Project Name: BELMONT PLACE

**CITY OF ALBUQUERQUE
PLANNING DEPARTMENT
March 19, 2008
DRB Comments**

RE: Lots 23 and 24, Block 5, Belmont Place

Plat of
 Lots 23-A and 24-A, Block 5
Belmont Place
 Albuquerque, Bernalillo County, New Mexico
 January 2008

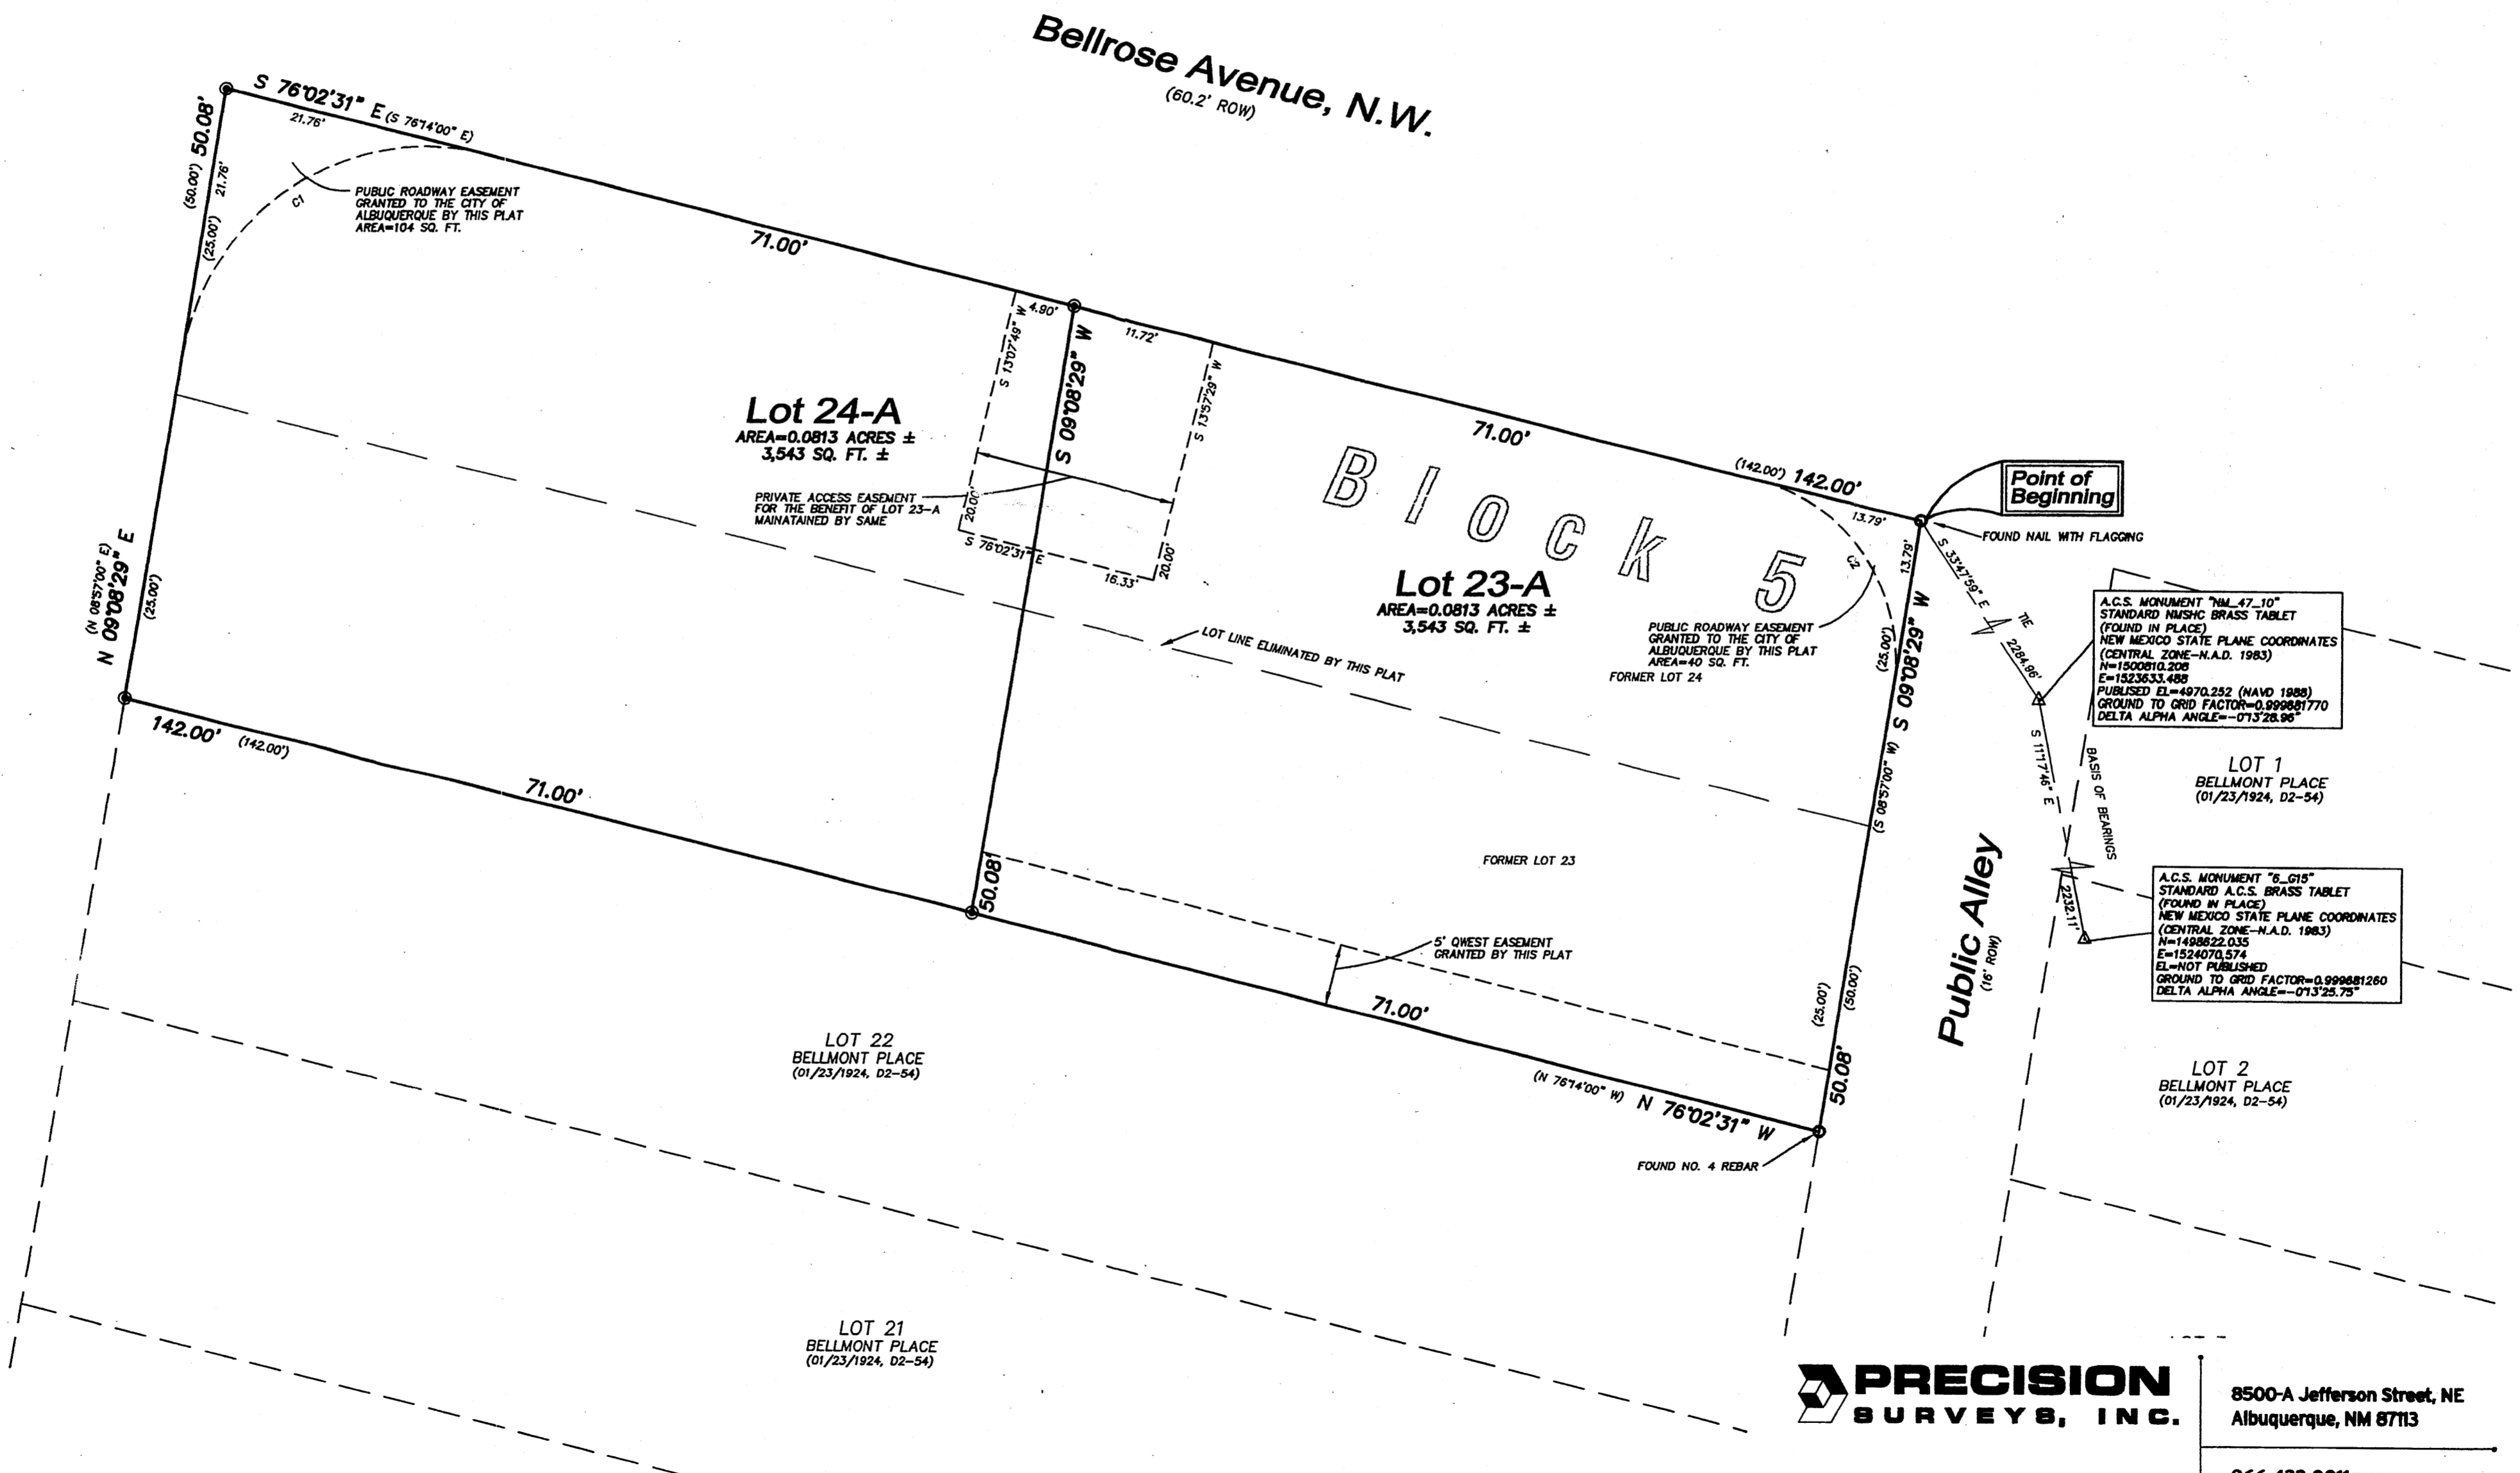
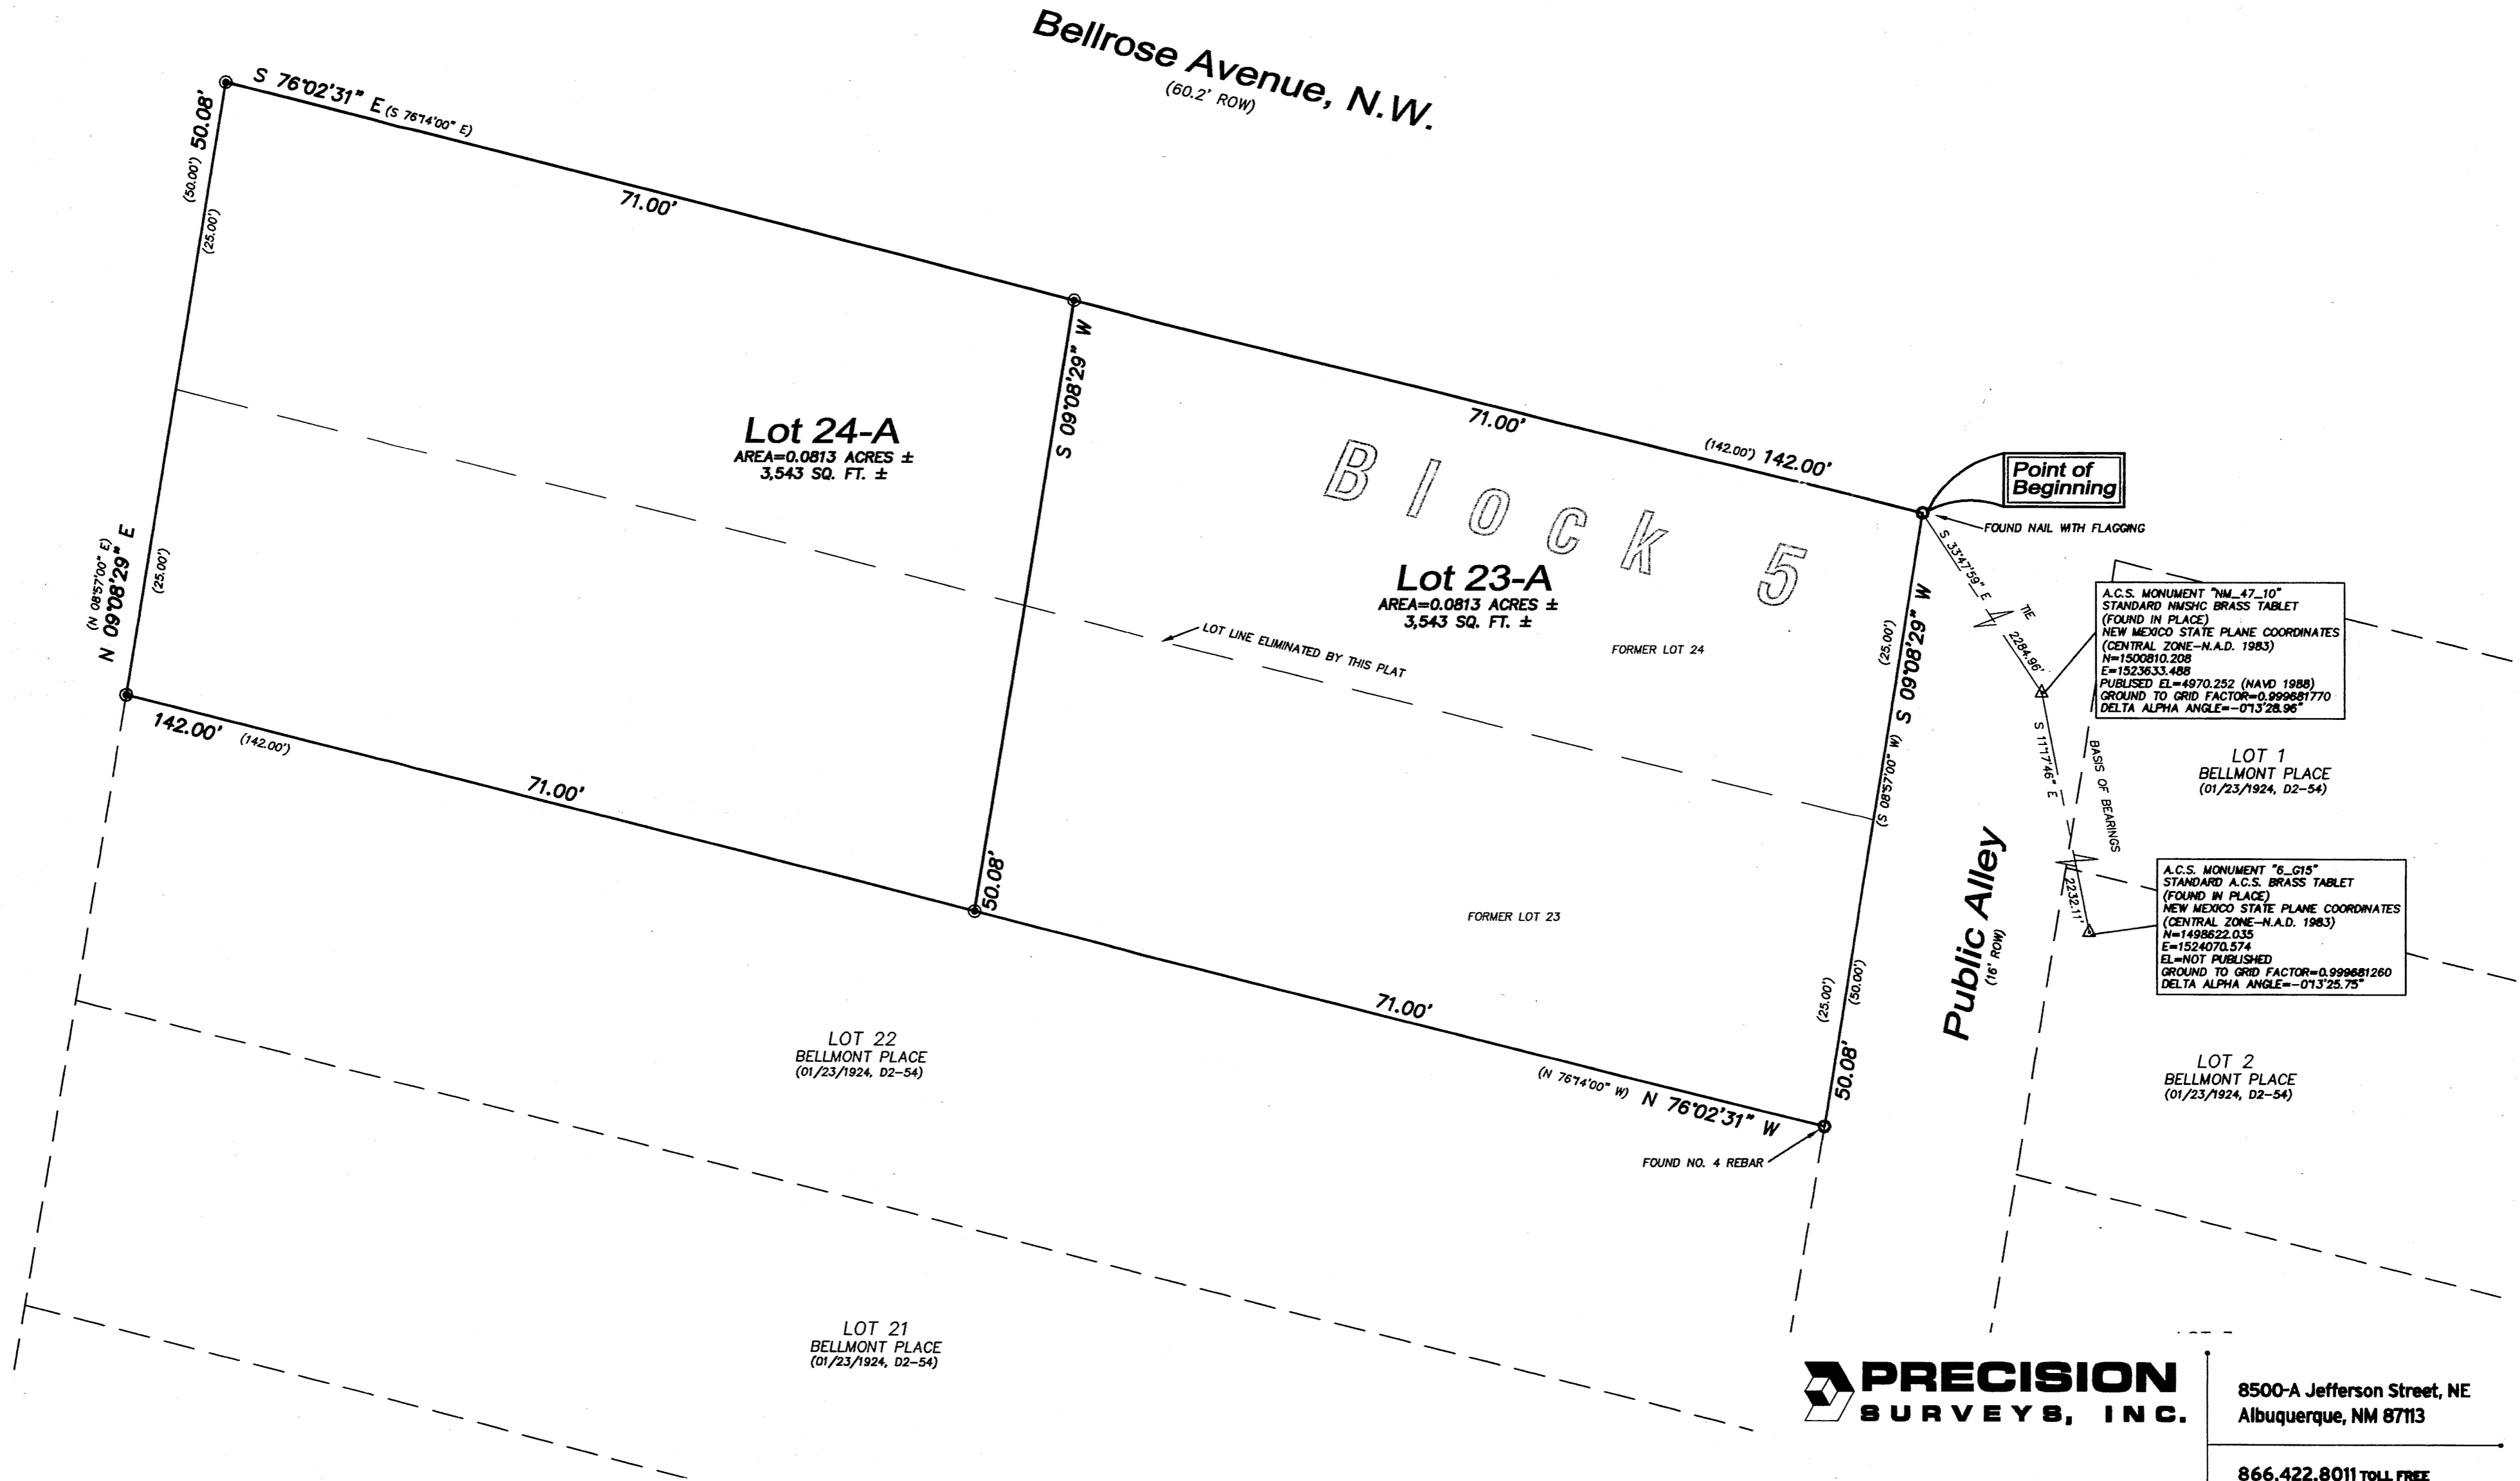
The existing garage must be removed prior to filing of plat.

Plat of
Lot 25-A, Block 5
Belmont Place
 Albuquerque, Bernalillo County, New Mexico
 January 2008

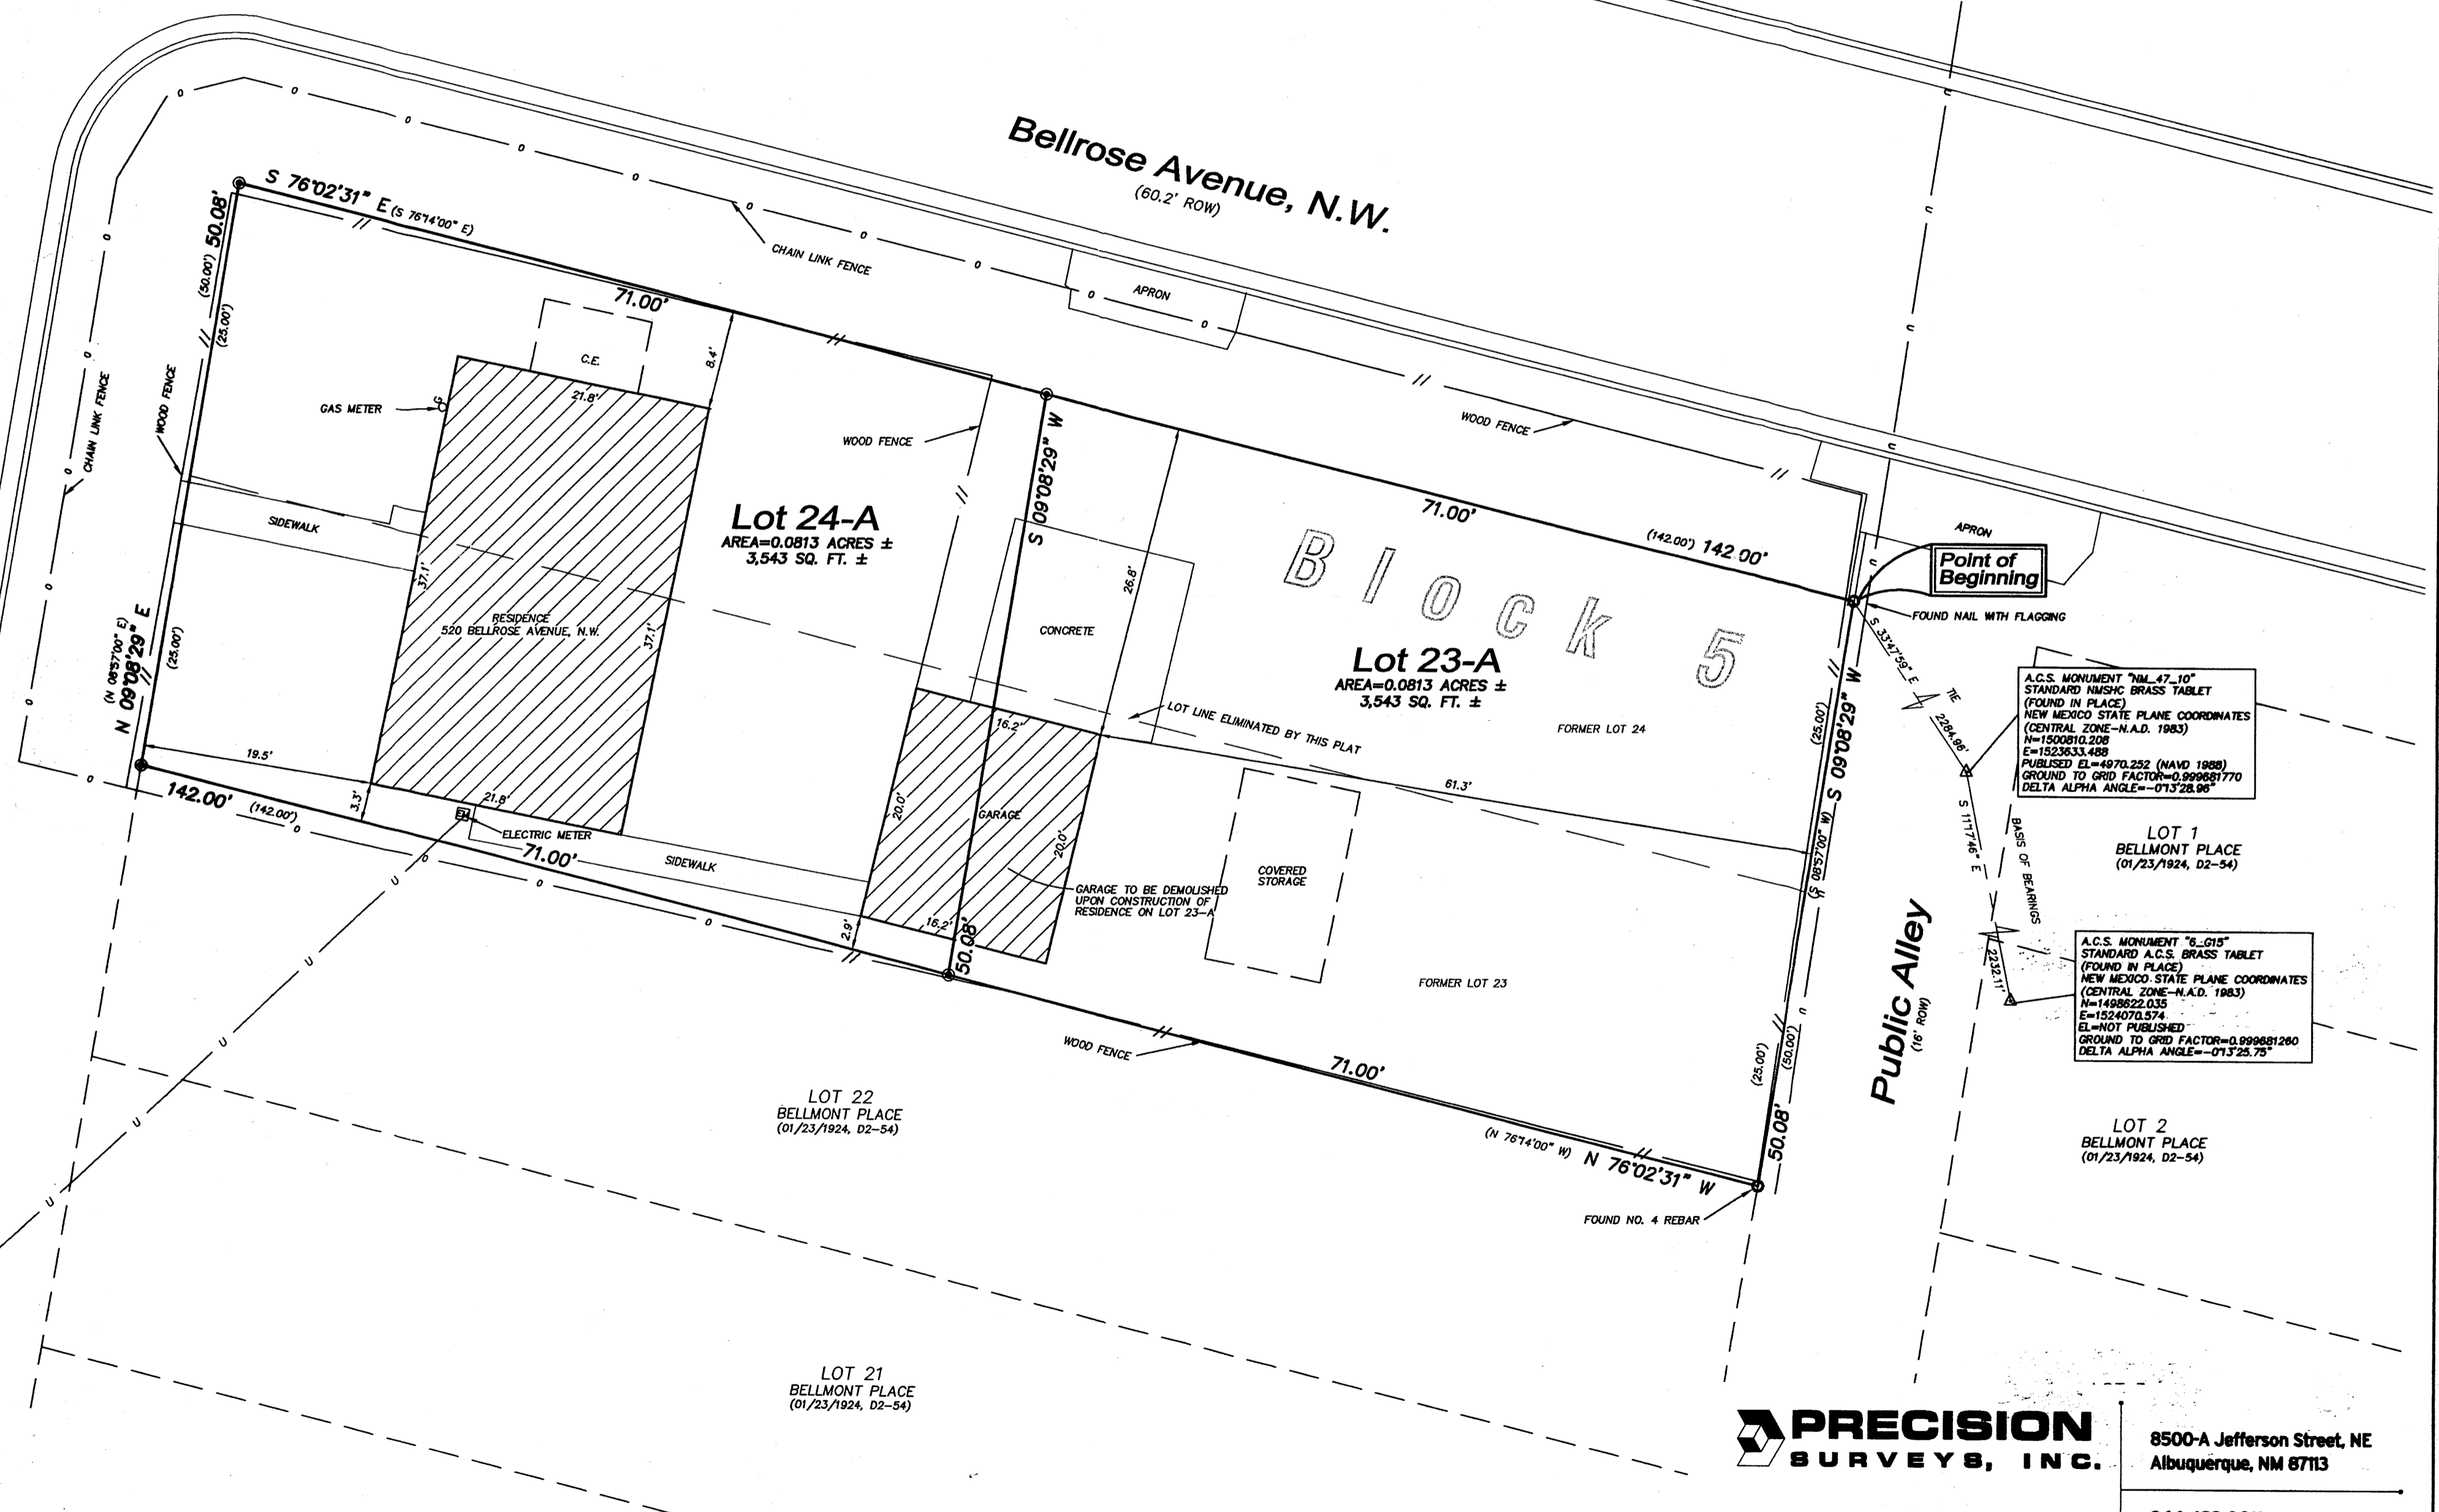
Please revise/ correct Sheet 3 or delete from plat.
